DRB Application No.: 04DRB-01090 (SBP)  
Project Name: MARIPOSA SQUARE  
Agent: Jim Medley, Architect AIA

**August 25, 2004 DRB Comments**

**PROJECT # 1003548      APPLICATION # 04-01090**

**RE: 4 U Car Wash/SPBP revised submittal**

Sheet: **C1**

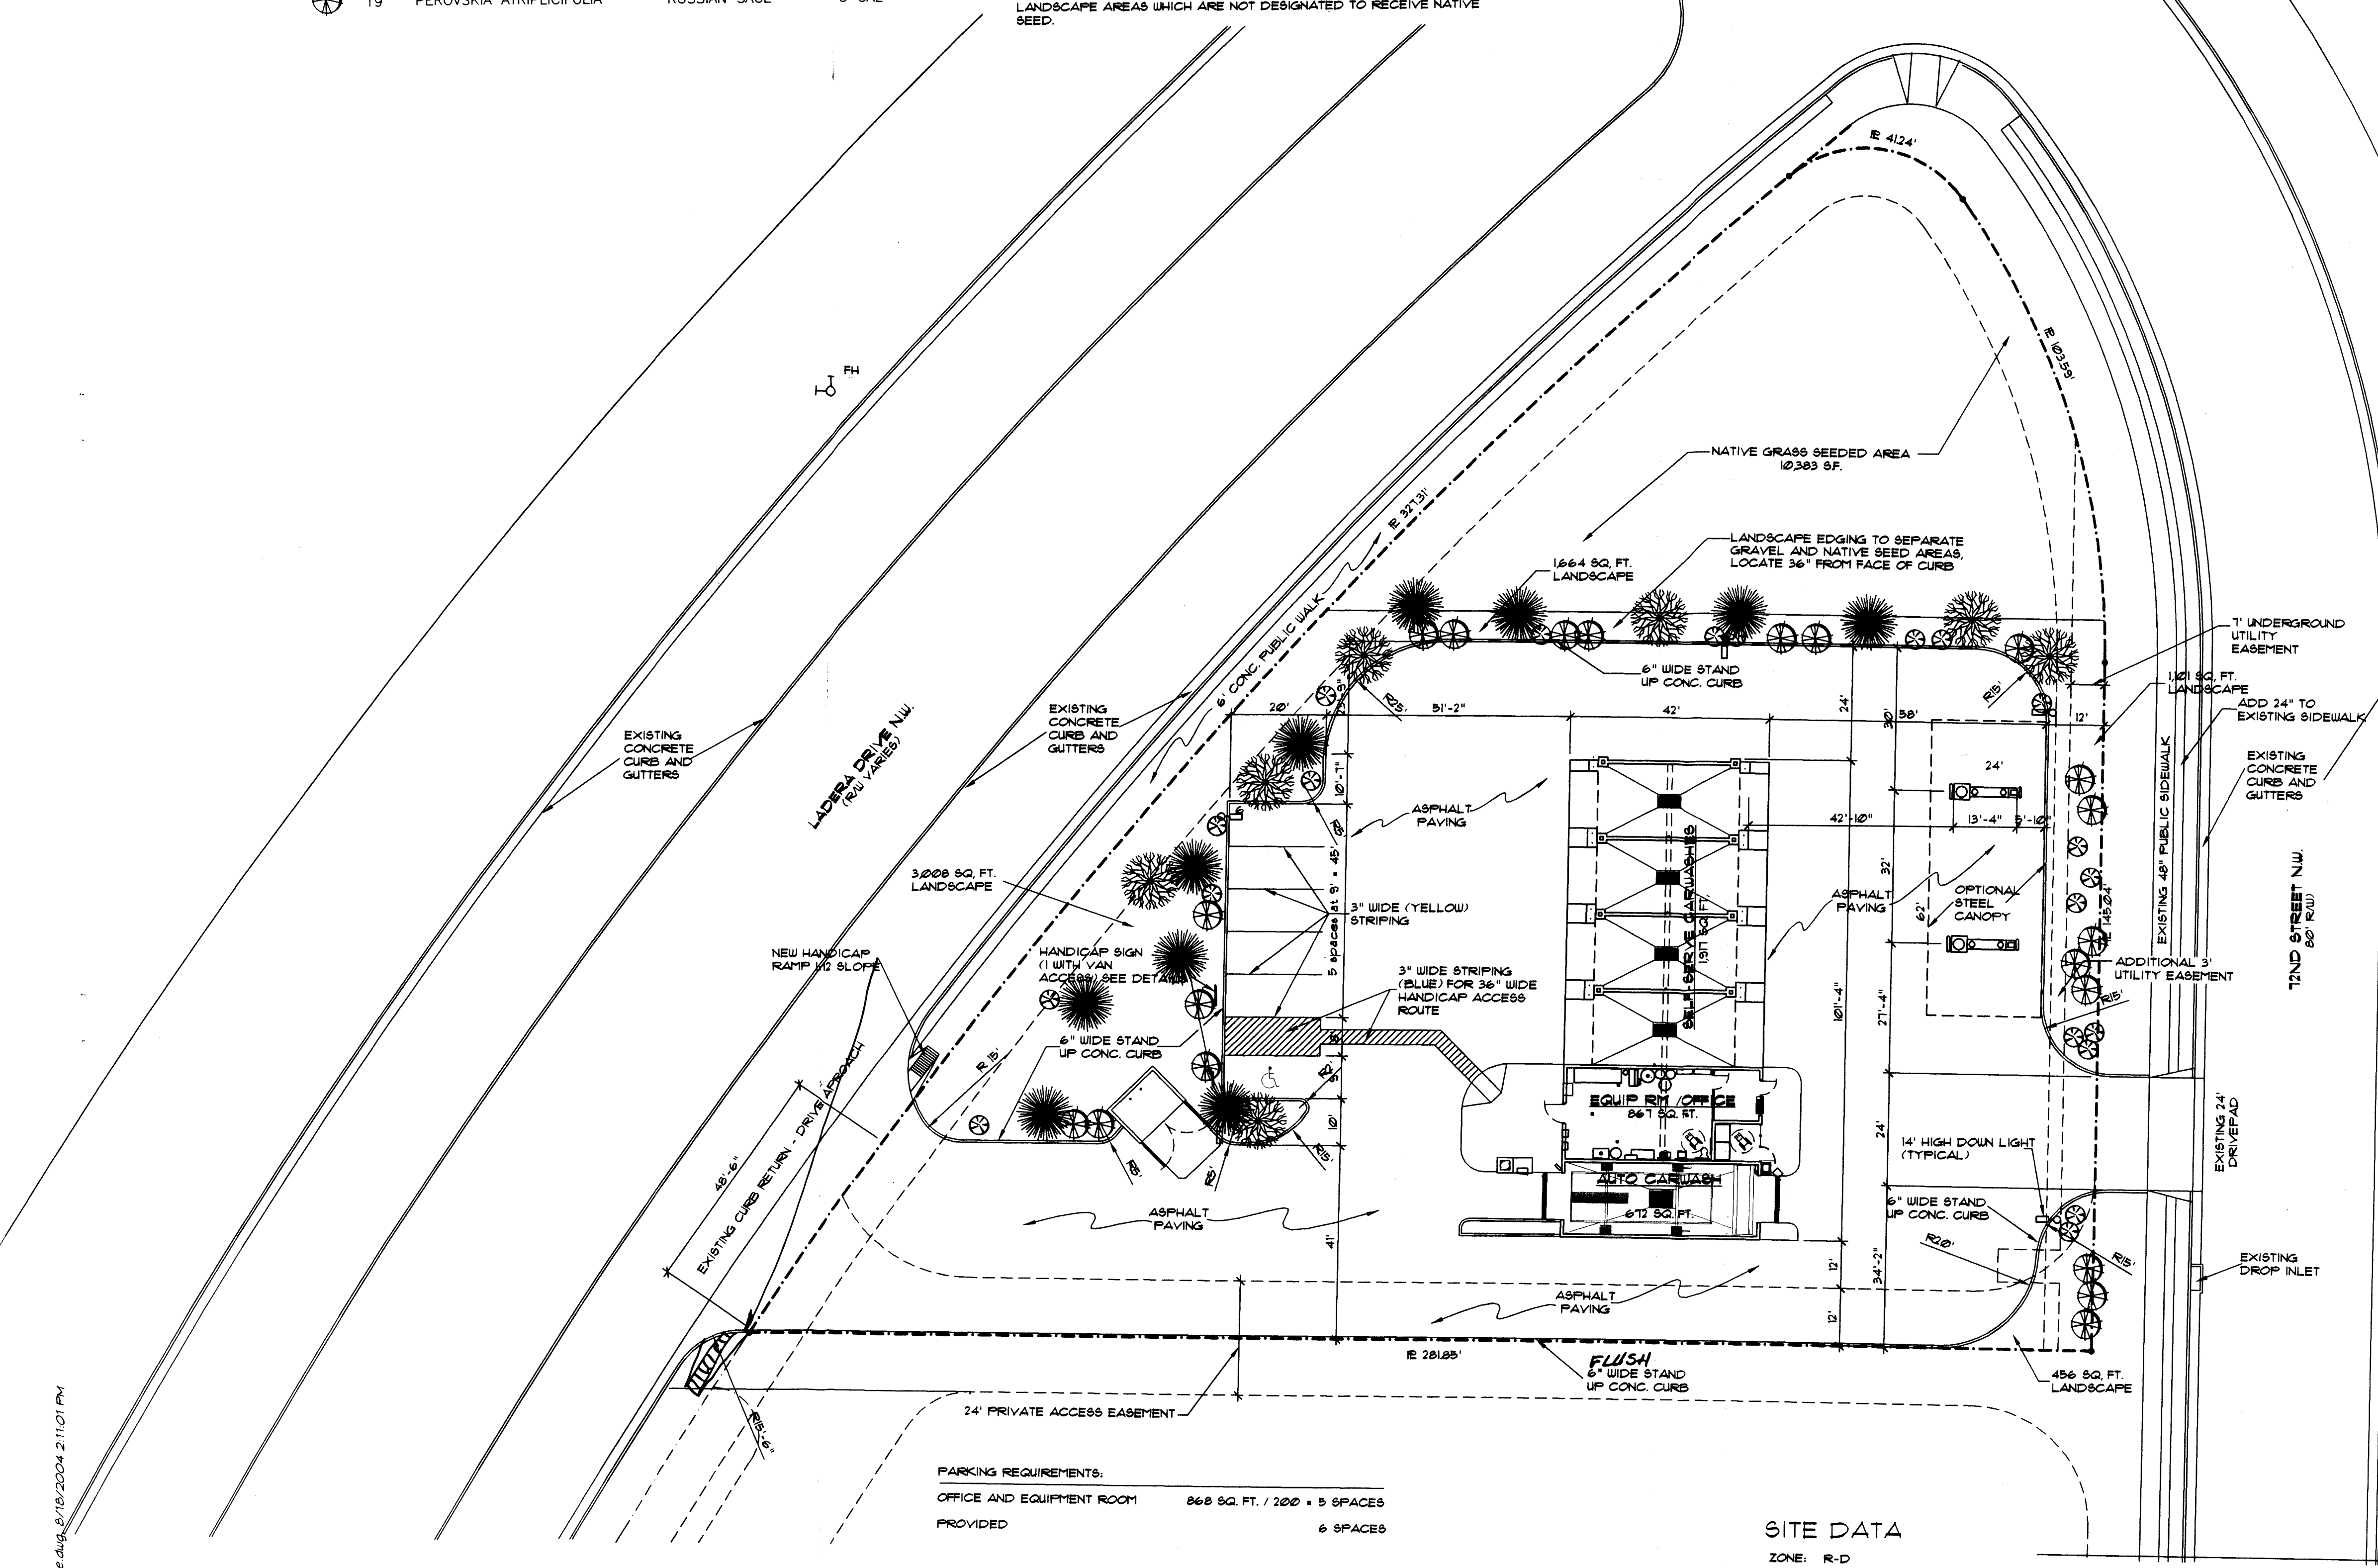
- ✓ **▪ Square Footage and use for each structure needed on this sheet per Checklist.**
- ✓ **▪ Square footage of each landscaped area required per Checklist.**
- ✓ **▪ Solid Waste's signature is required on the original SPBP prior to Planning signing the SPBP.**

SOUTH ELEVATION

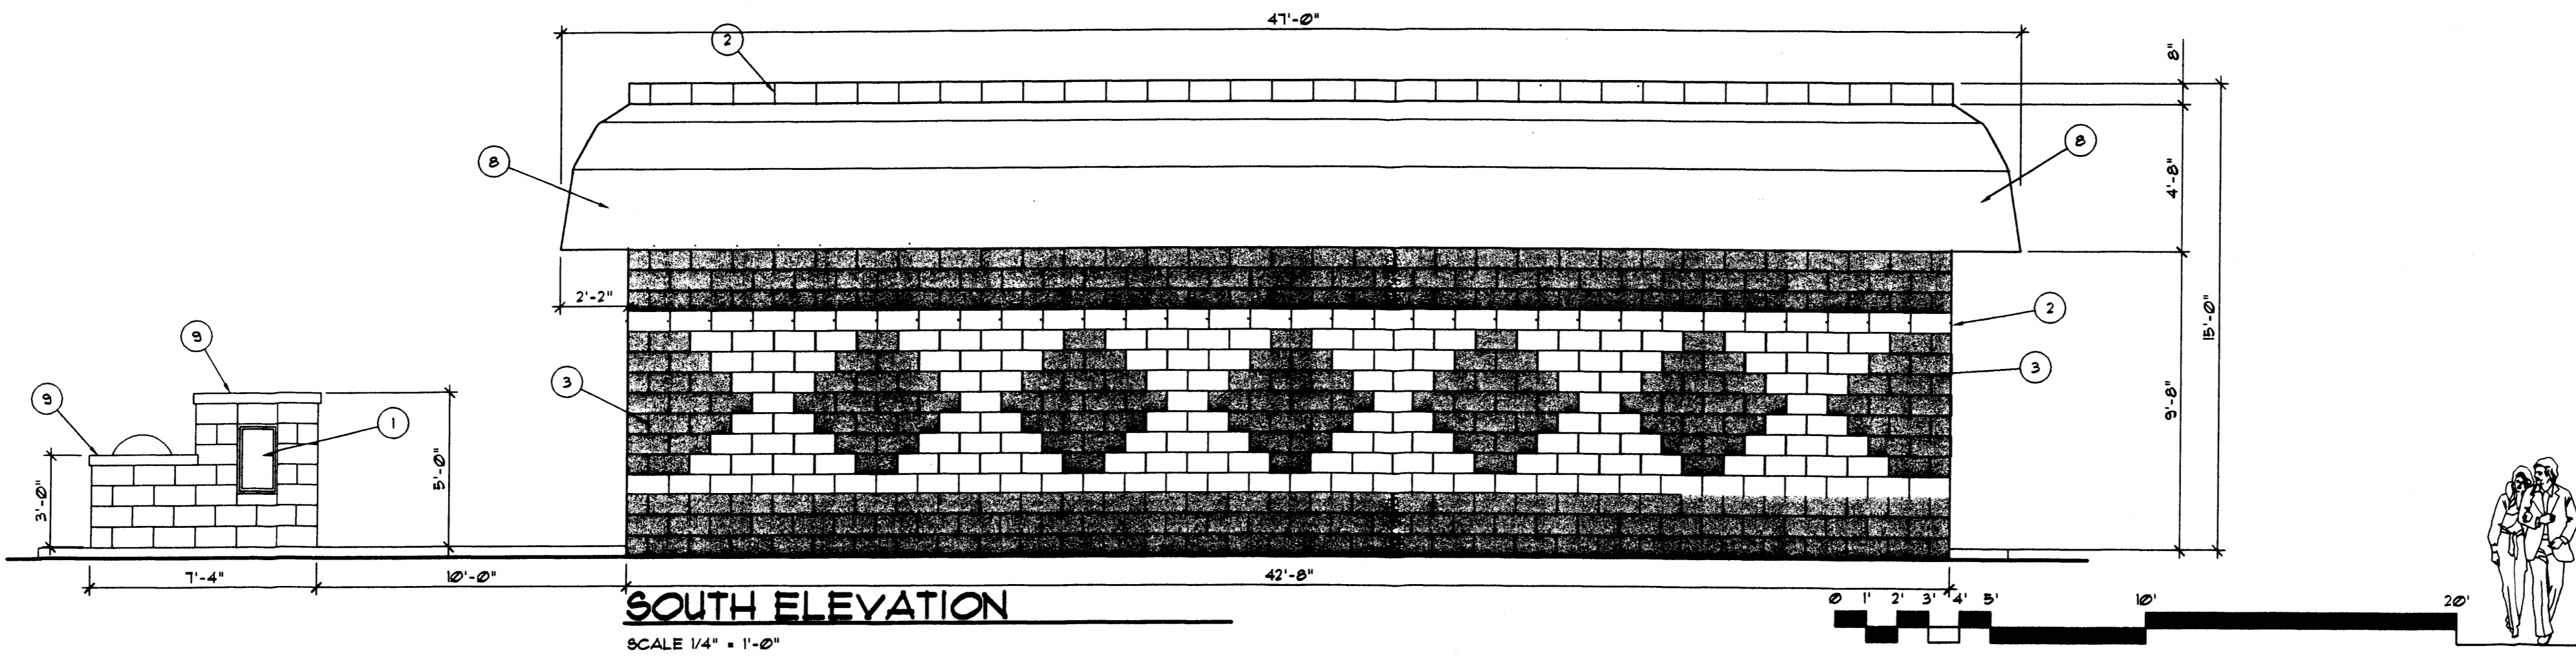
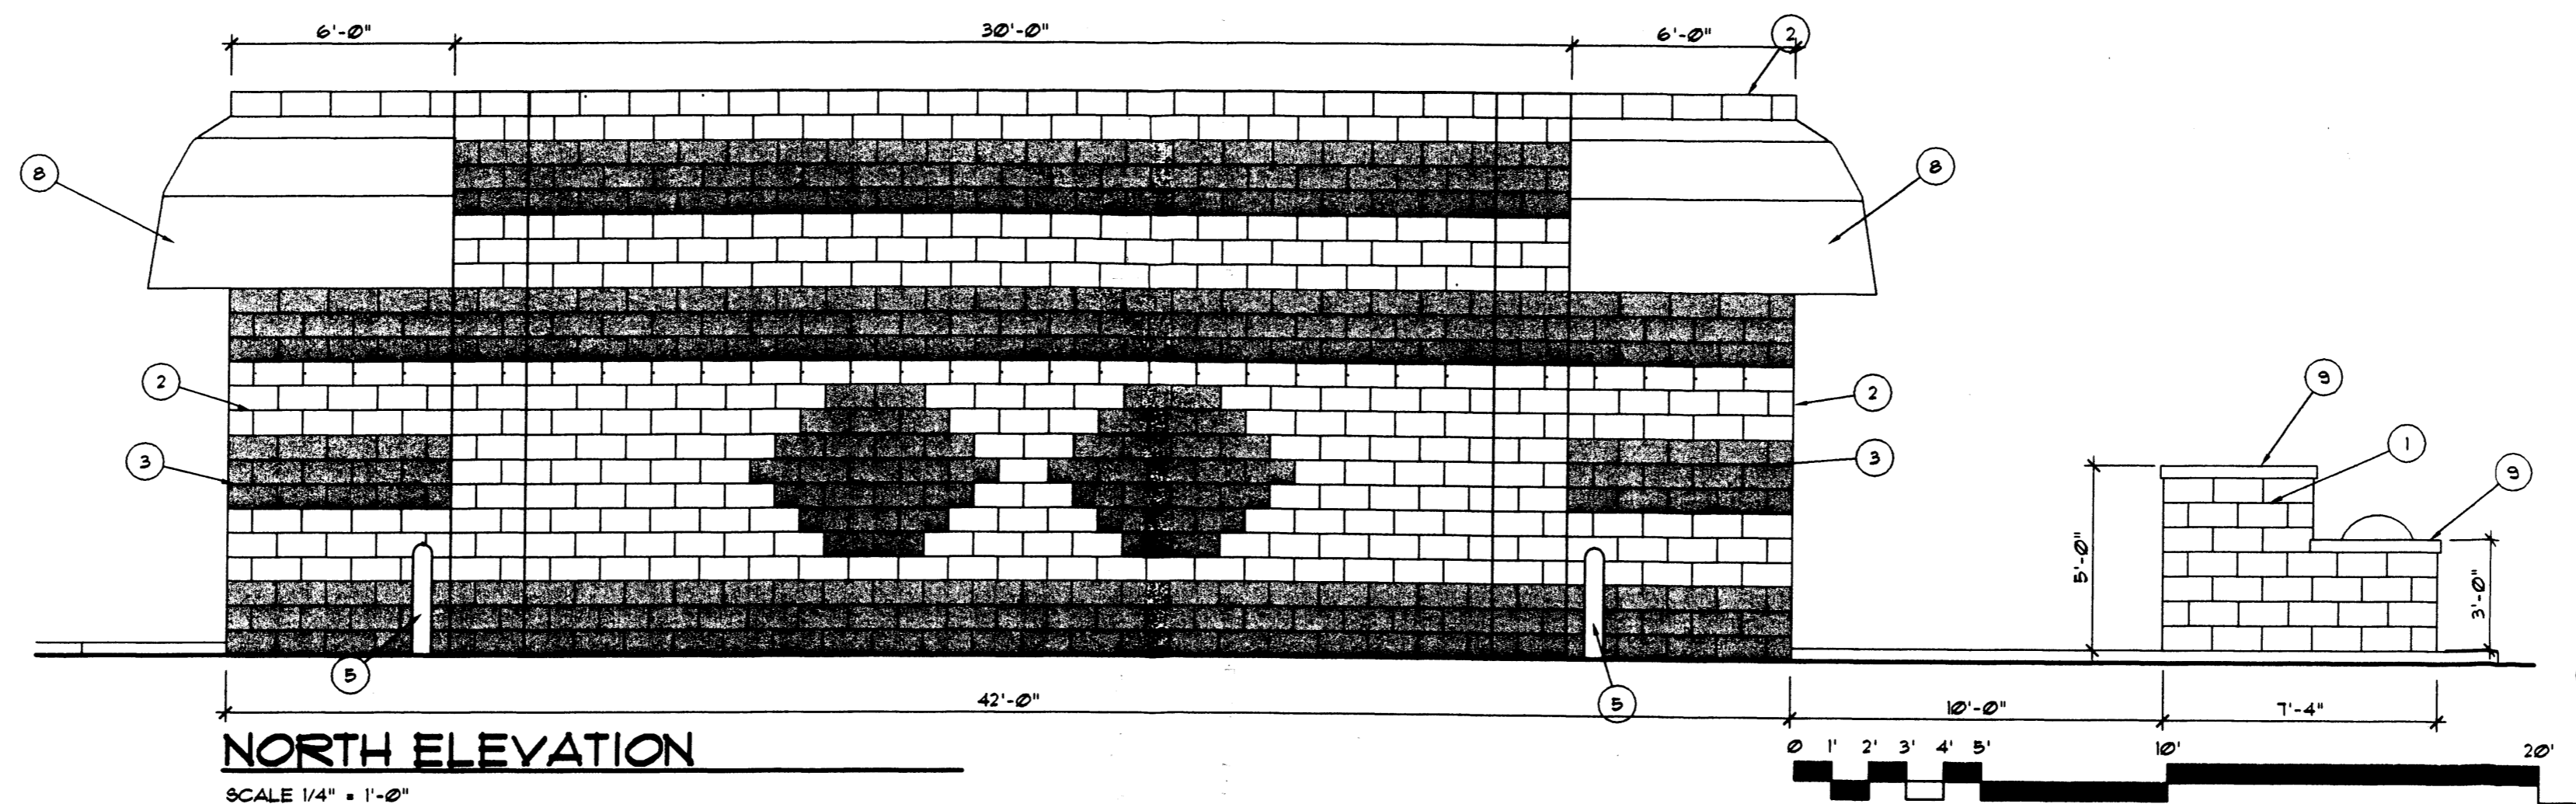
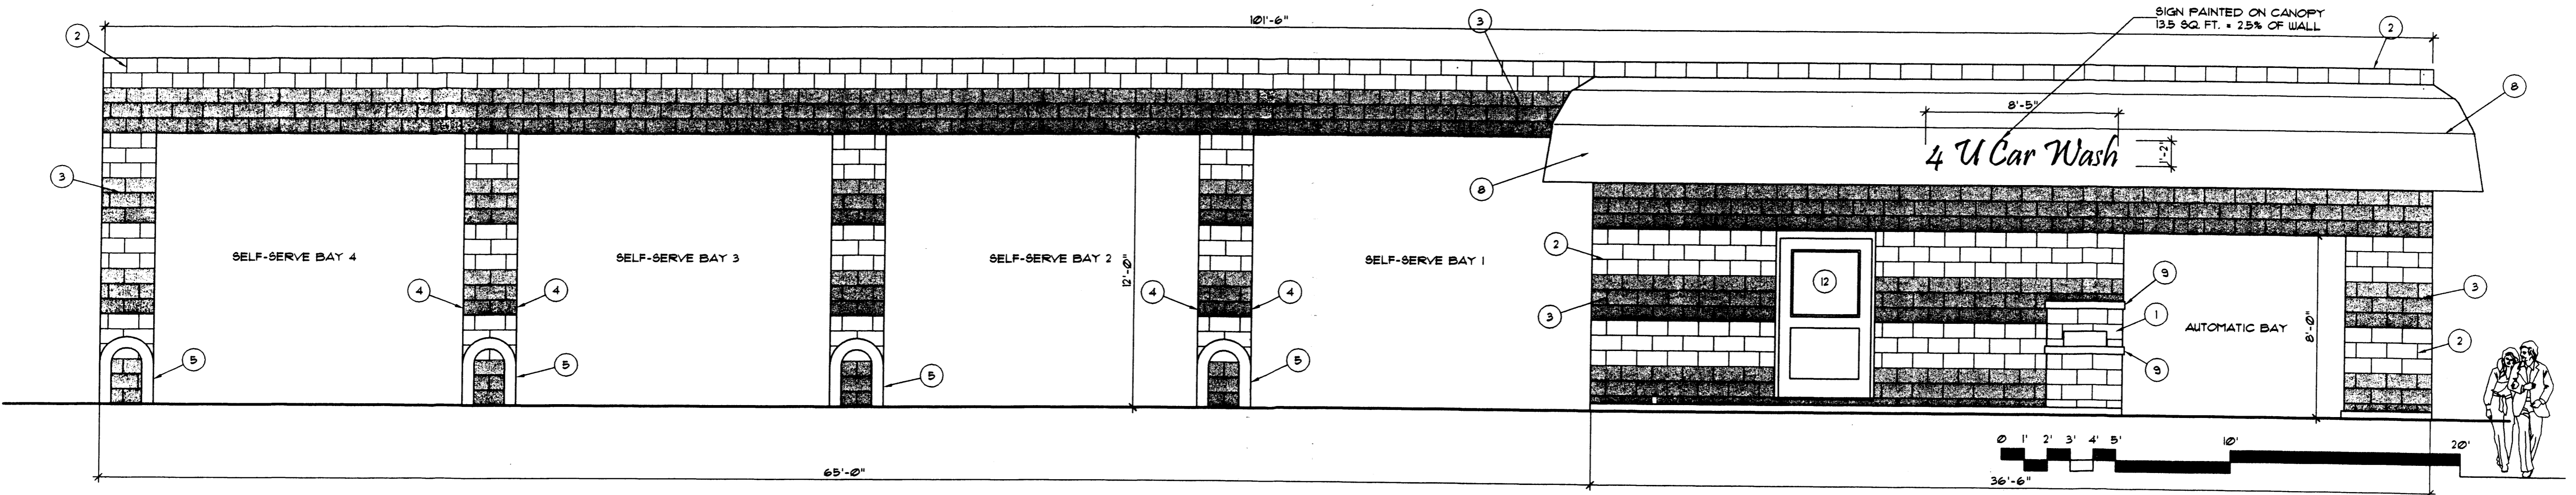
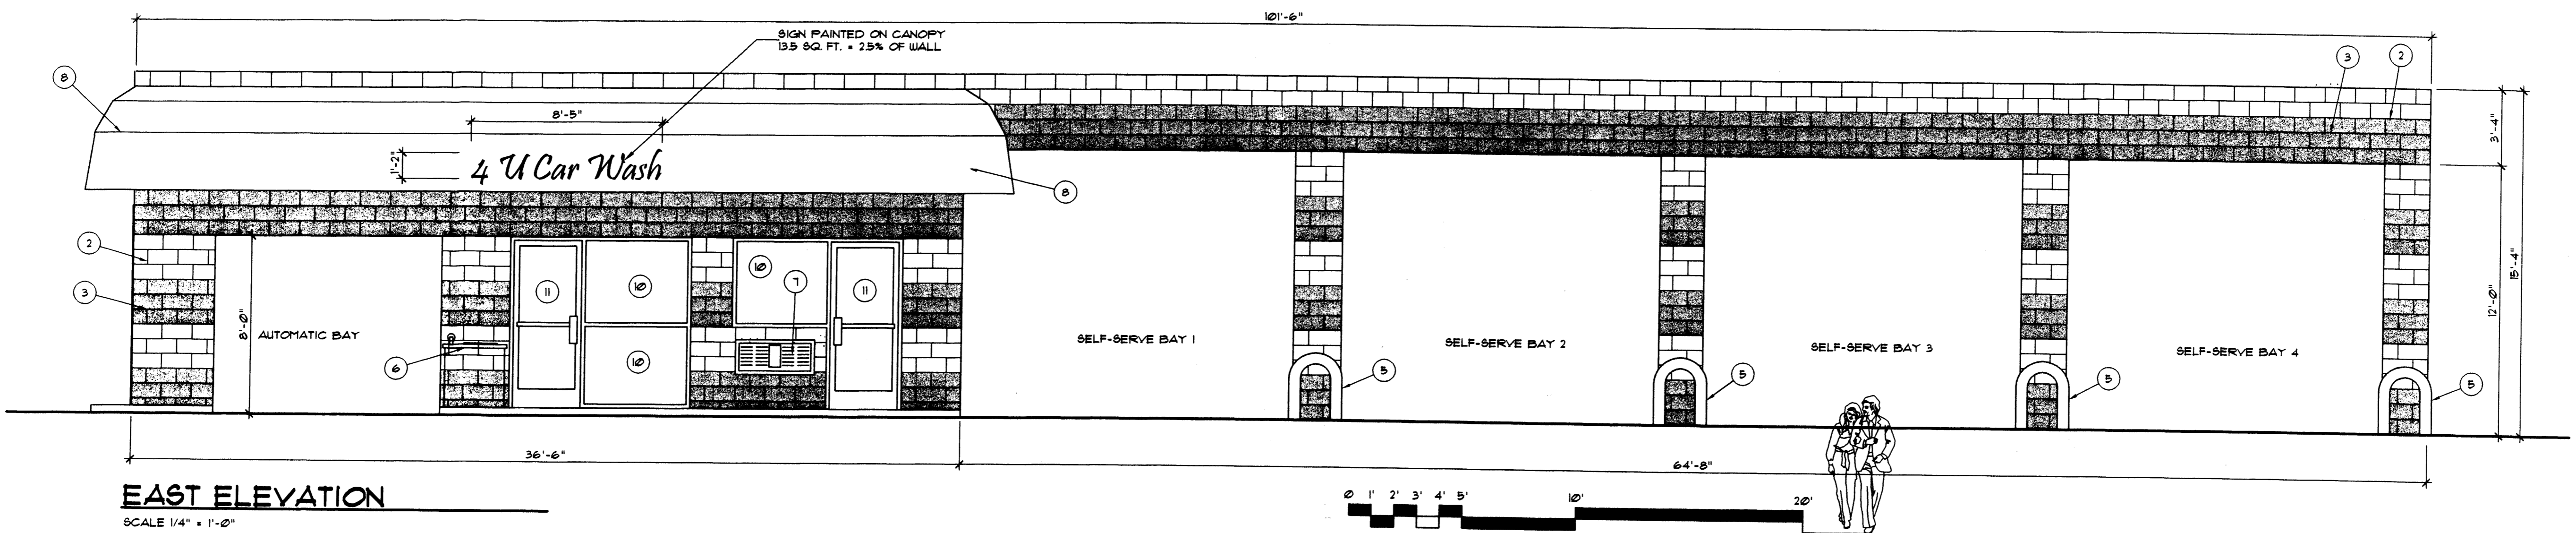
- ✓ **▪ Site Elements. Section 14-16-2-16(A)(11)(b)(3)(b) does not allow a free standing sign on a premises less than 5 acres in Developing Urban area of the Comprehensive Plan in which this site is located. An application for a variance or special exception to the Zone Code through the Zoning Hearing Examiner might be considered.**

- ✓ **▪ One canopy sign per entrance or exit is permitted.**
- ✓ **▪ Please remove the Preliminary Floor Plan Sheet from the DRB submittal. It is not required nor approved by DRB.**

- ✓ **▪ Building Elevations Sheet. Remove the word "Preliminary" from the title.**
- ✓ **▪ Colors for CMU split space must be specified as do the colors of the awning and the sign on the awning.**

- ✓ **▪ The dimensions of the building & awning signs must also be on the elevations sheet. The size of each sign is not to exceed 25% of the façade area to which it is applied. Section 14-16-2-16(A)(11)(c)(2)(a)(ii) of the Zone Code.**

- ✓ **▪ Overall width of each elevation is missing. Required per the Checklist.**
